From: Geoff Palmer [REDACTED]
Sent: 14 August 2015 10:44
To: Planning
Subject: Fwd: Planning Application K/22/15/CLP (Broadbeach, 39 Coastal Road)

Further to the representation on the above planning application which we made via the website yesterday, we have attached a photograph to illustrate why we consider the proposals in the above planning application fall outside the scope of Permitted Development.

Proposed Ground Floor Plan
(alterations and extensions)

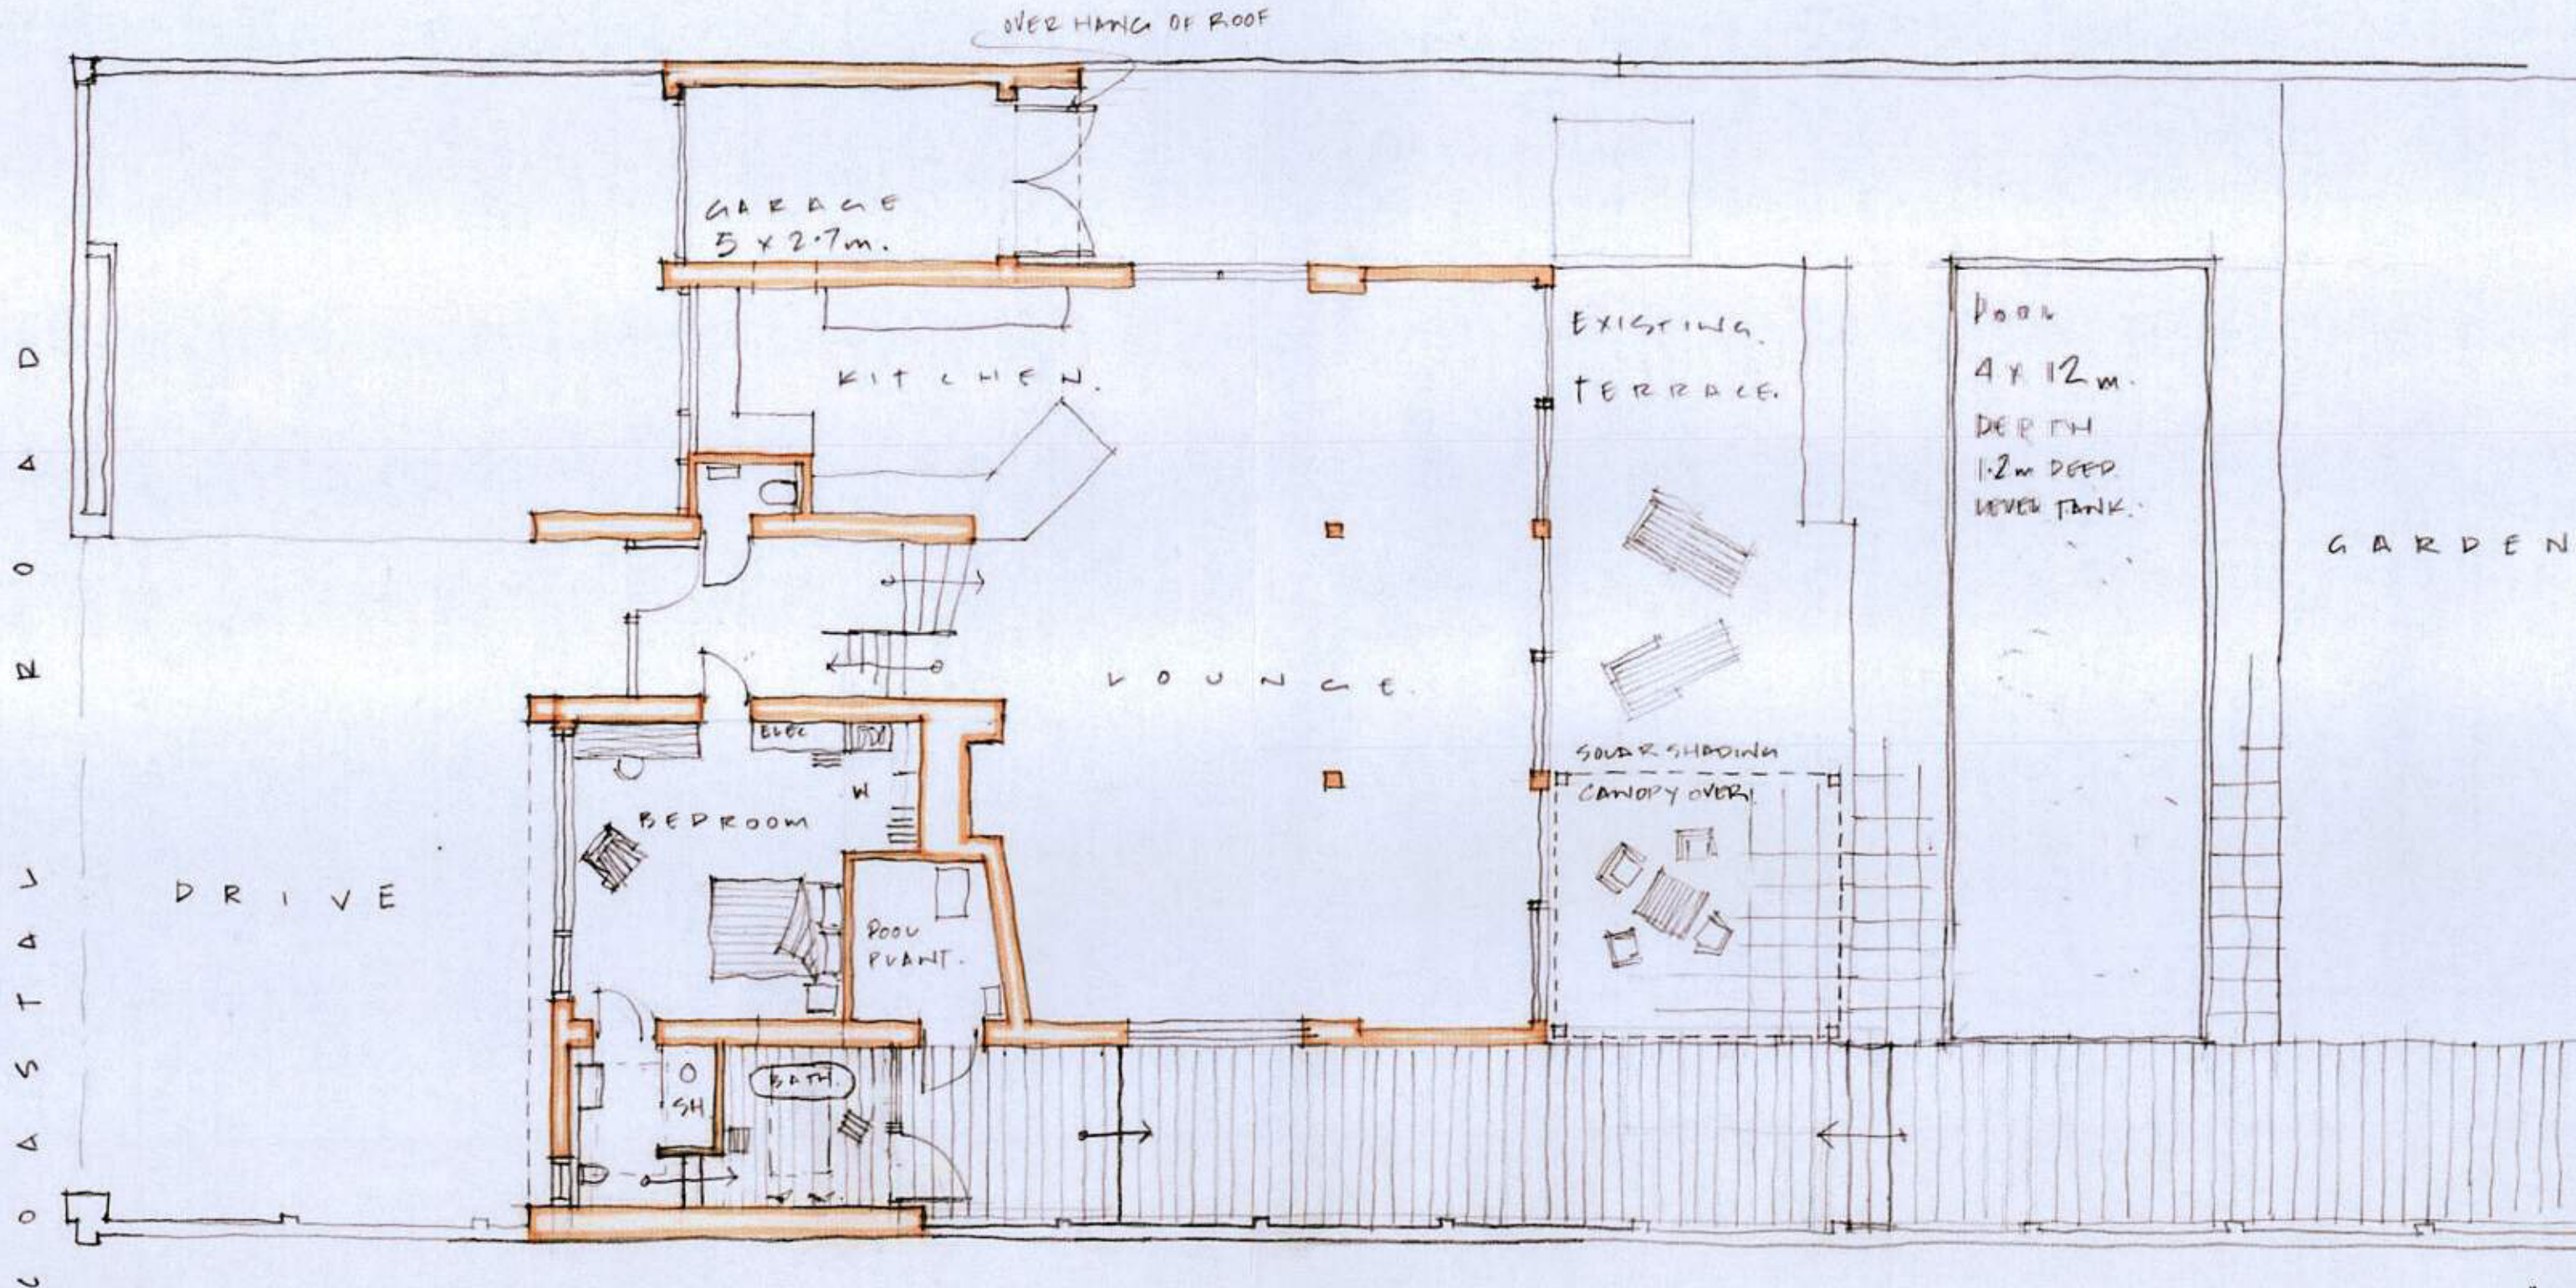
The Planning Order 2015 relating to Permitted Development states that "Development is not permitted by Class A *"if it would consist of or include an alteration to any part of the roof of the dwellinghouse"* (Class A.1.(k)(iv)). Part of this roof is being raised in order to convert the integral garage into a bedroom which falls into the scope of Class A (the *"enlargement, improvement or other alteration of a dwelling house"*). It is therefore not Permitted Development.

Proposed West & East Elevations  
(alterations and extensions)

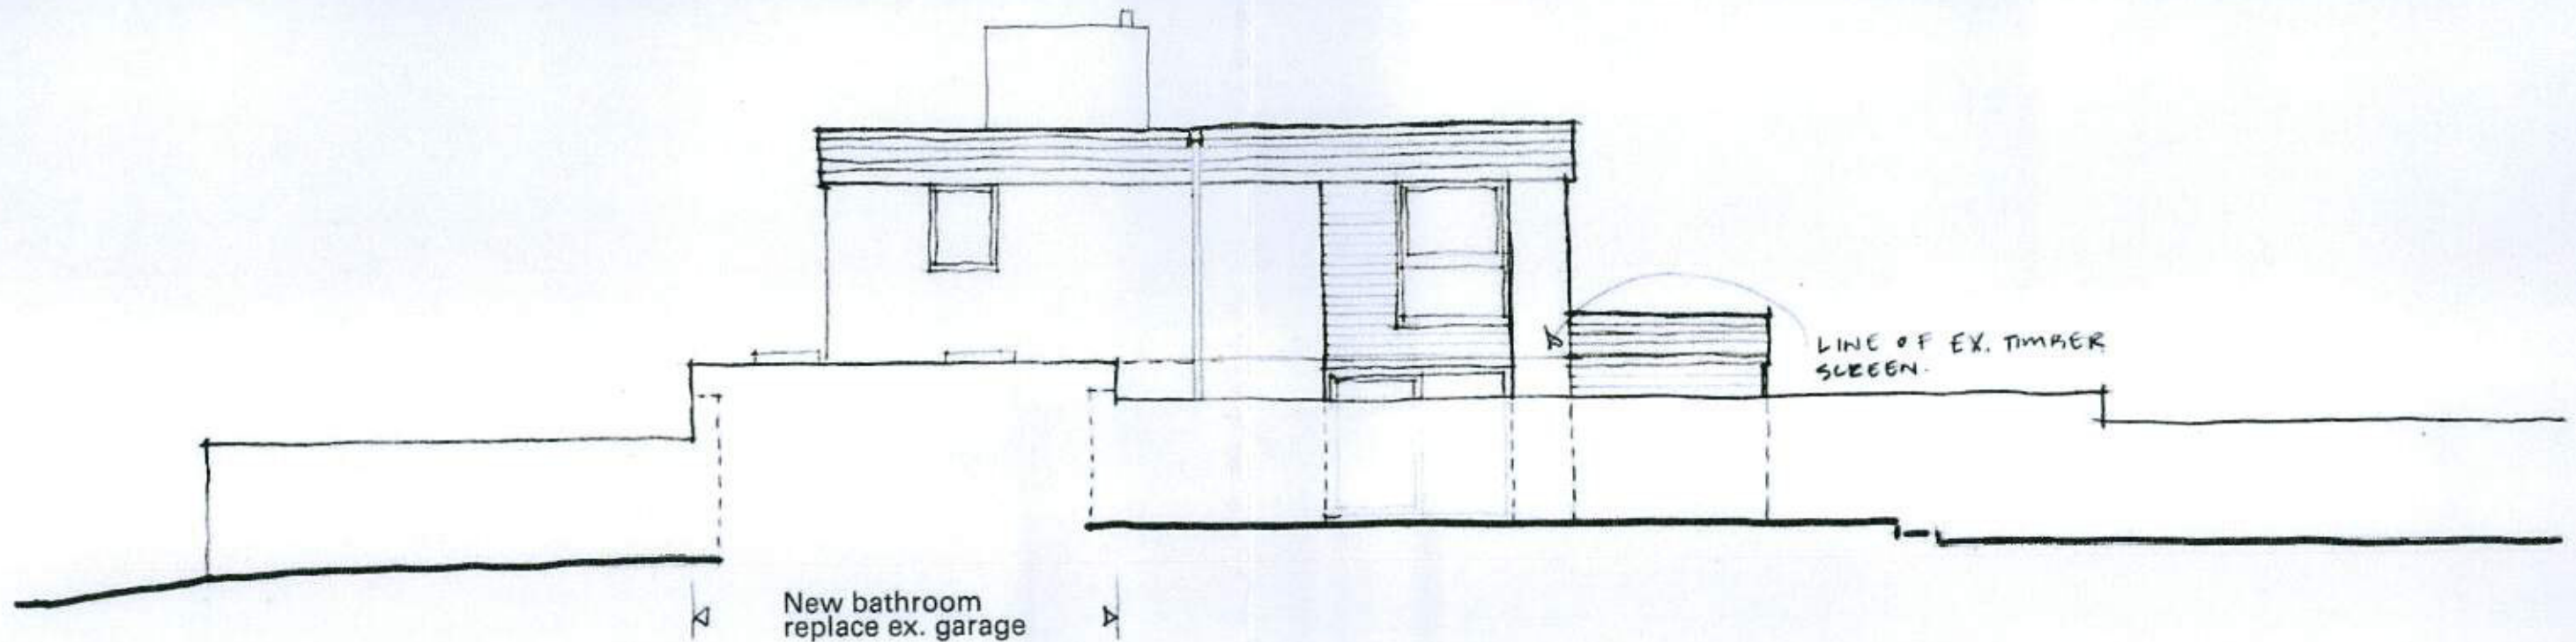
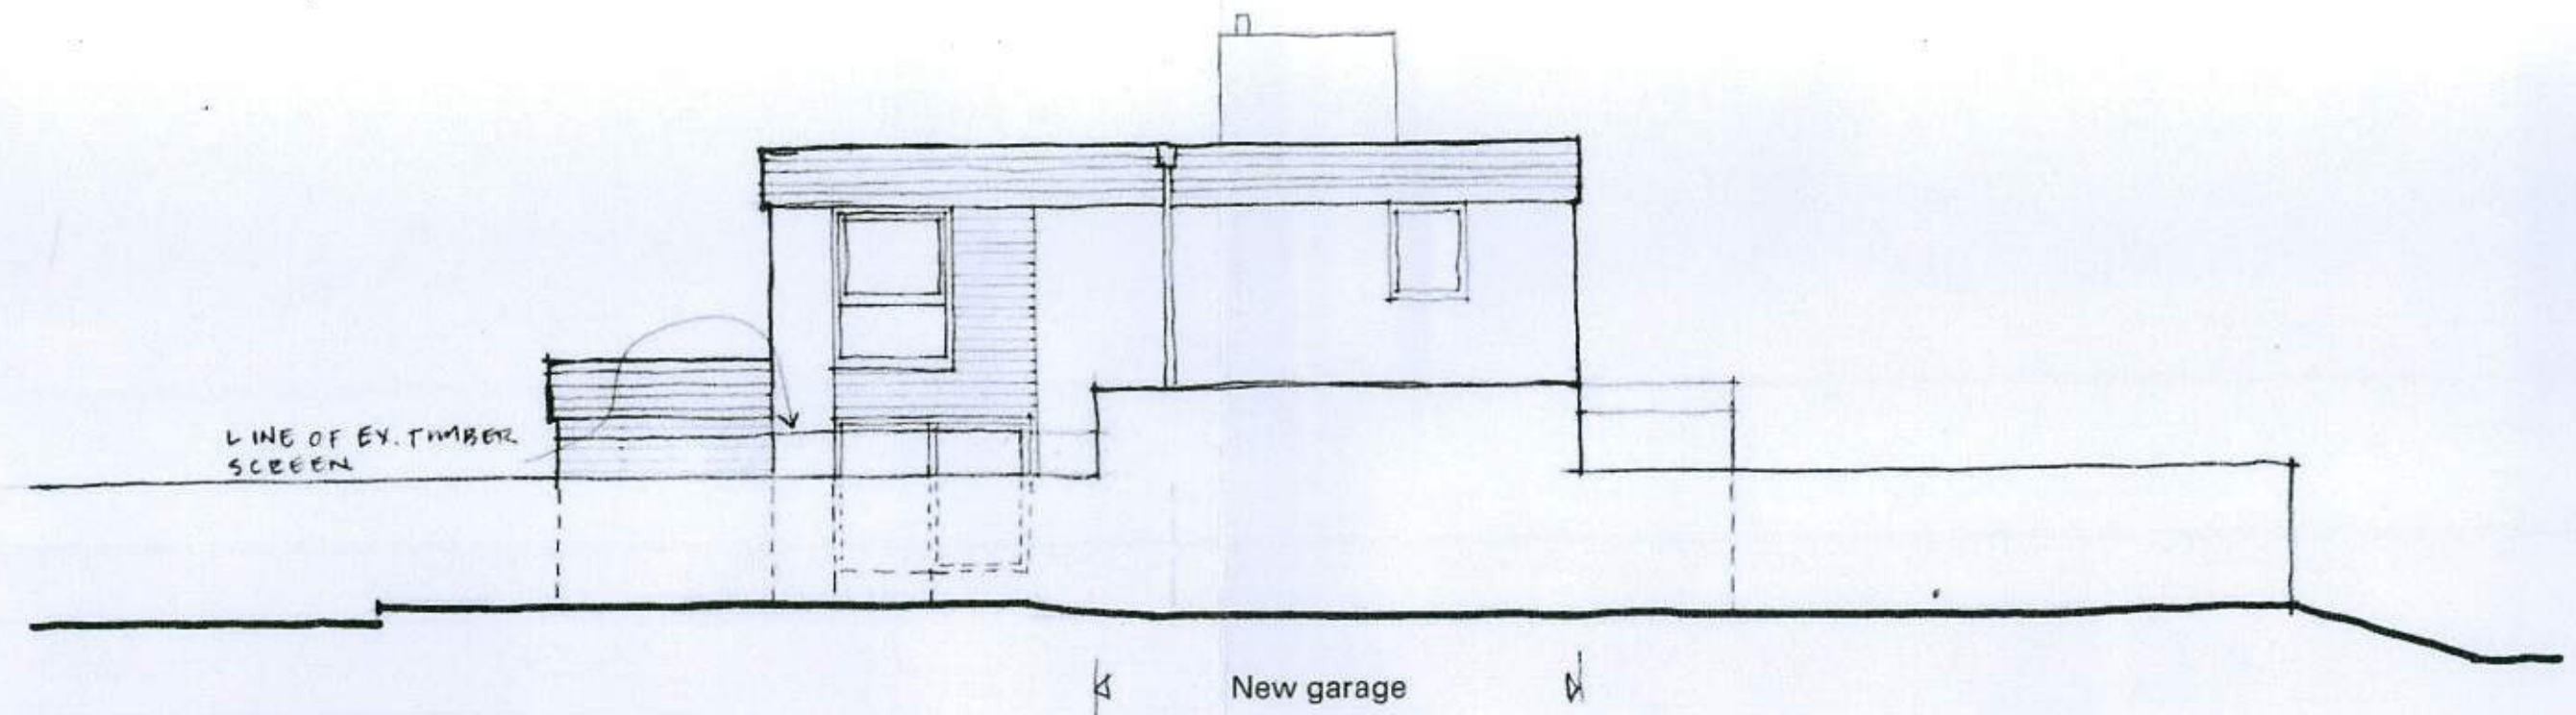
The existing flat roof above the porch, entrance hall and integral garage is part of the original property as constructed in the late 1960s. The applicants are proposing to replace part of this roof with a higher roof which extends to the side of the property as indicated.

We understand that alterations to the roof are permitted under Class B of the Planning Order providing that *"other than the case of an enlargement which joins the original roof to the roof of a rear or side extension, no part of the enlargement extends beyond the outside face of any external wall of the original part of dwellinghouse"* (Class B.2. (b)(ii)). However, this does not apply in this case as it is a new roof (not the original roof) which would be joined to the new side extension.
